**Marine
Management
Organisation**

MMO Reference: DCO/2022/00007
Planning Inspectorate Reference: EN010125
Identification Number: 20050160

Planning Act 2008, RWE Renewables UK Dogger Bank South (West) Ltd and RWE Renewables UK Dogger Bank South (East) Ltd Proposed Dogger Bank South Offshore Wind Farms Order

Department for Energy Security & Net Zero (DESNZ) – Further information Request – 06 November 2025

**'Without Prejudice' Herring Spawning Plan
(Revision 2)**

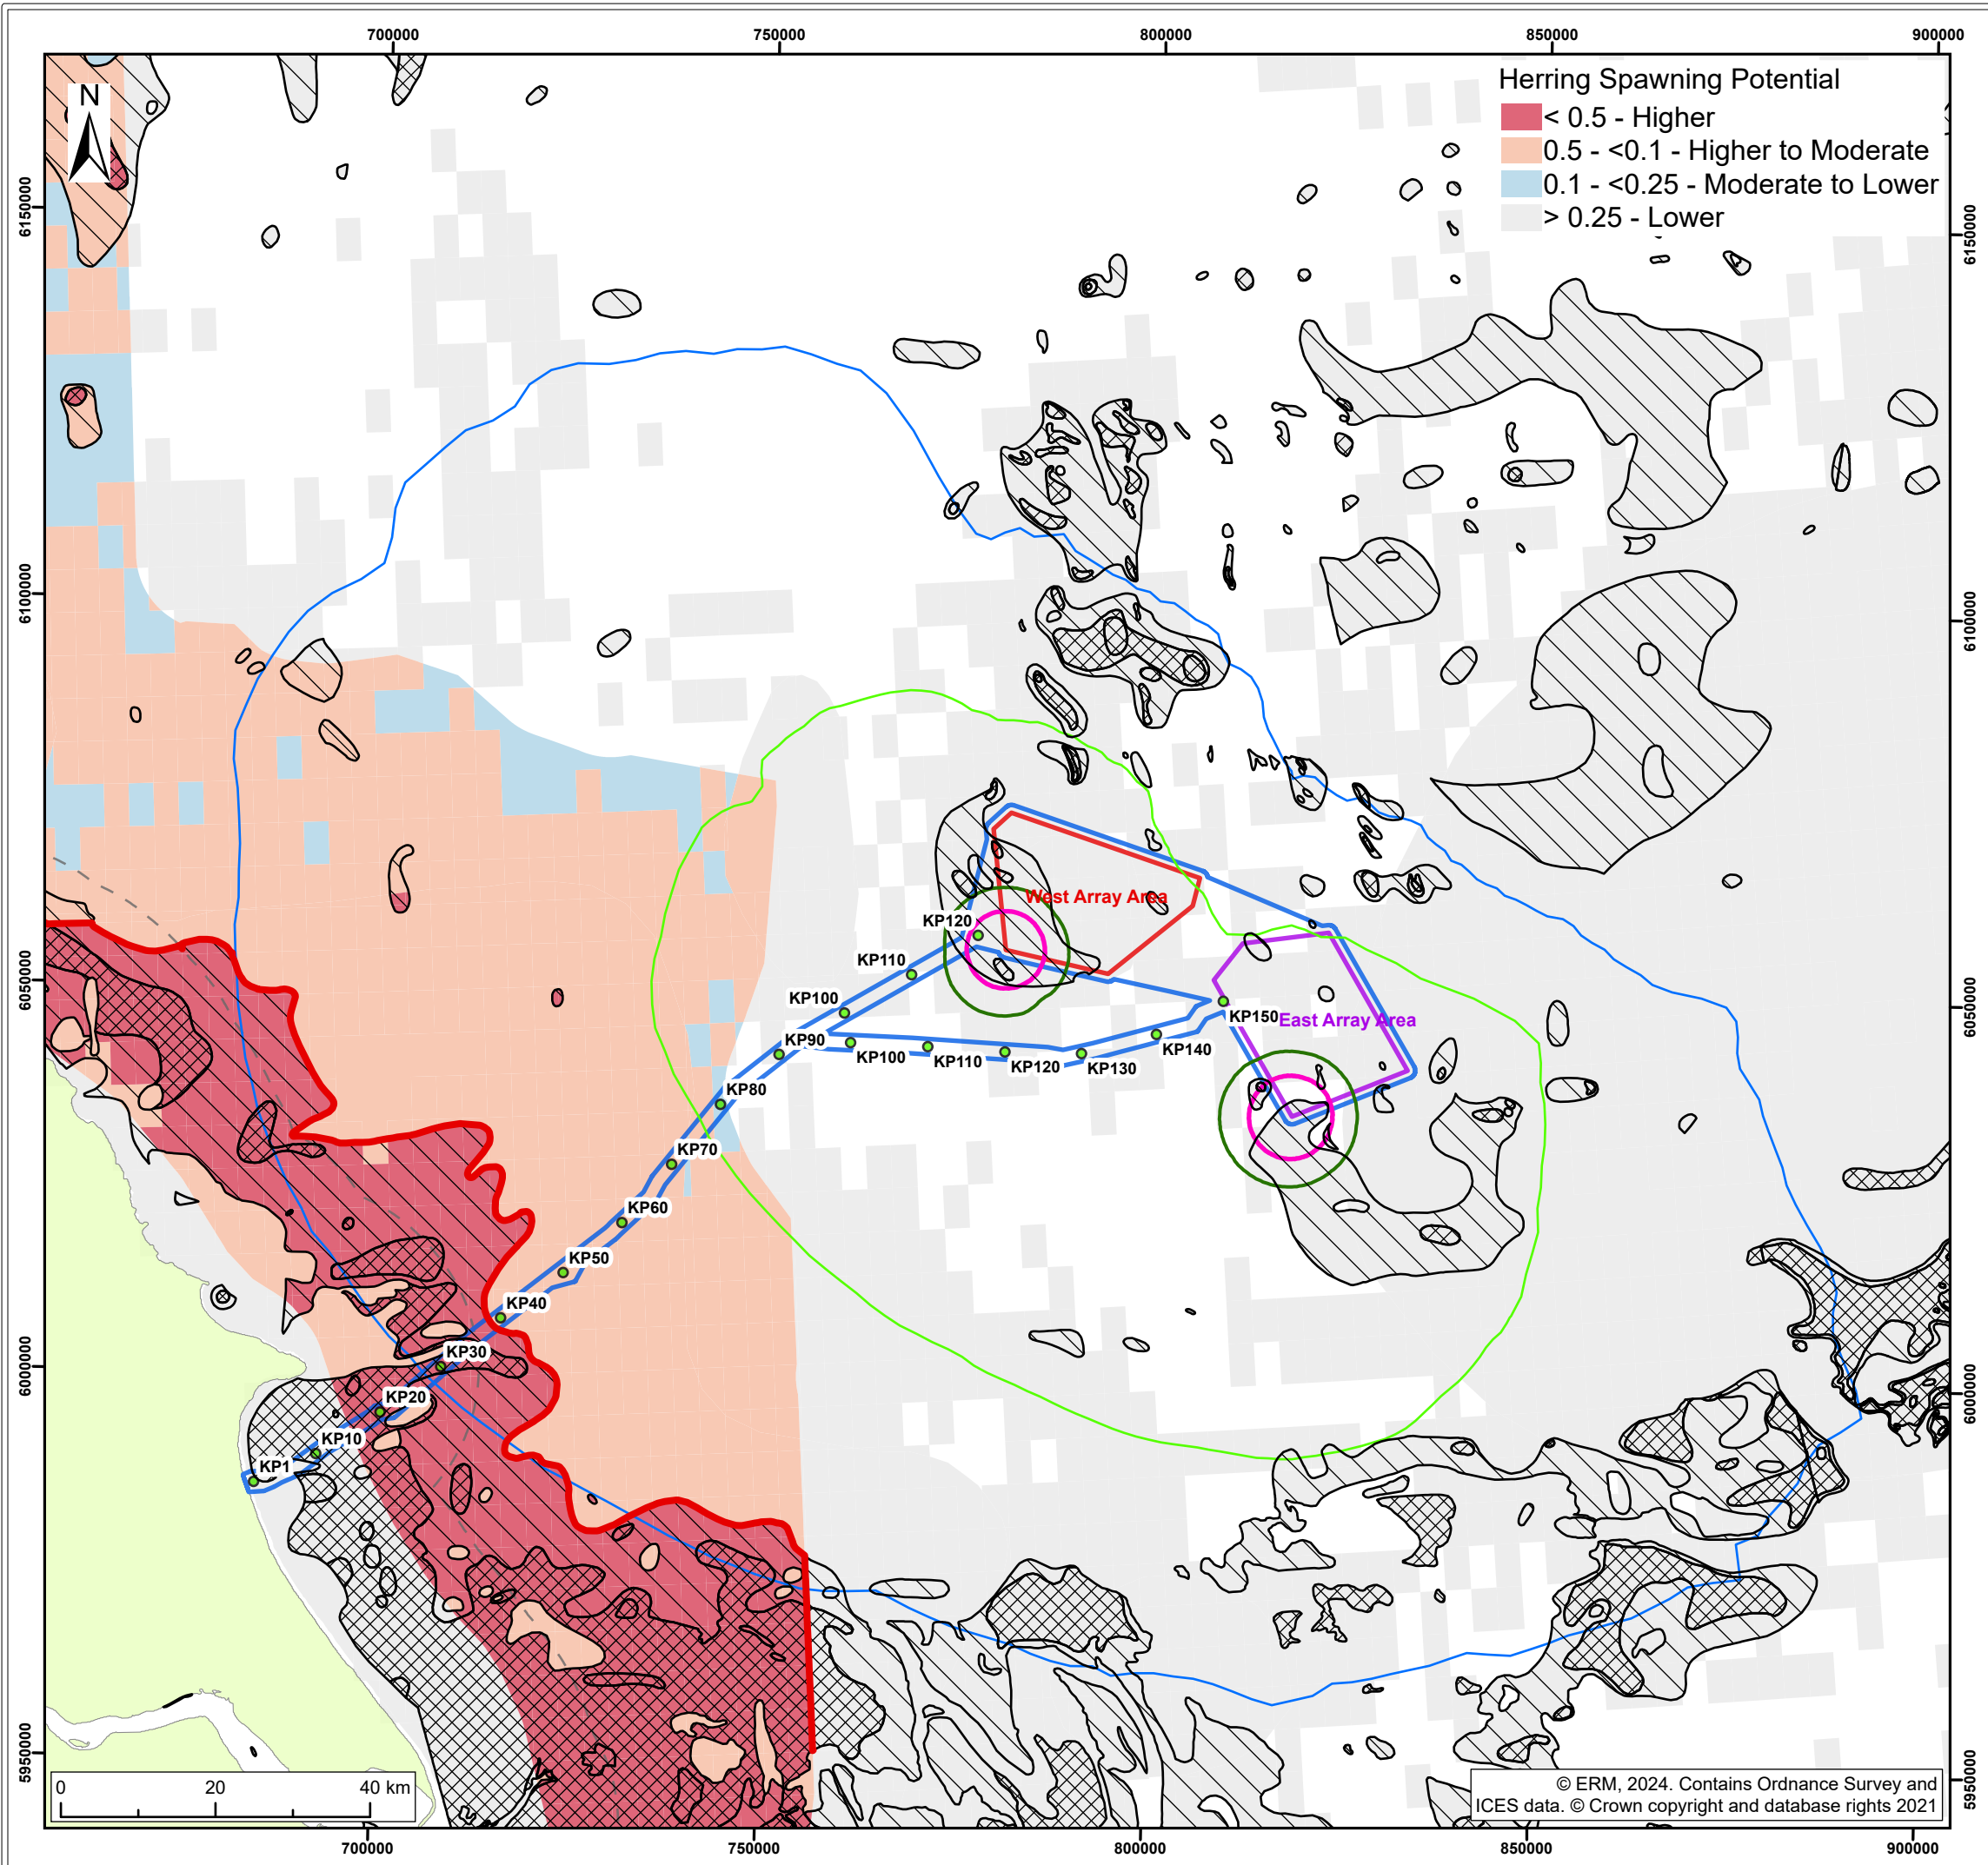
2.2 Paragraph 23 - The Secretary of State is aware that before the end of the examination, the MMO and NE did not have opportunity to comment on the updated Herring Spawning Plan [REP9-020]. The MMO and NE are invited to comment on the updated plan.

2.2.1 The MMO and the Applicants have been in discussions regarding the Herring Spawning plan. In October 2025 the following document was submitted to the SoS *"The Applicants' and the MMO's Post-Examination Joint Statement on the Without Prejudice Herring Noise Restriction"*. The MMO along with our scientific advisors Cefas have agreed a 38 kilometre (km) migratory route at the shortest distance and the location of the Herring Spawning Noise Restriction Boundary as originally proposed.
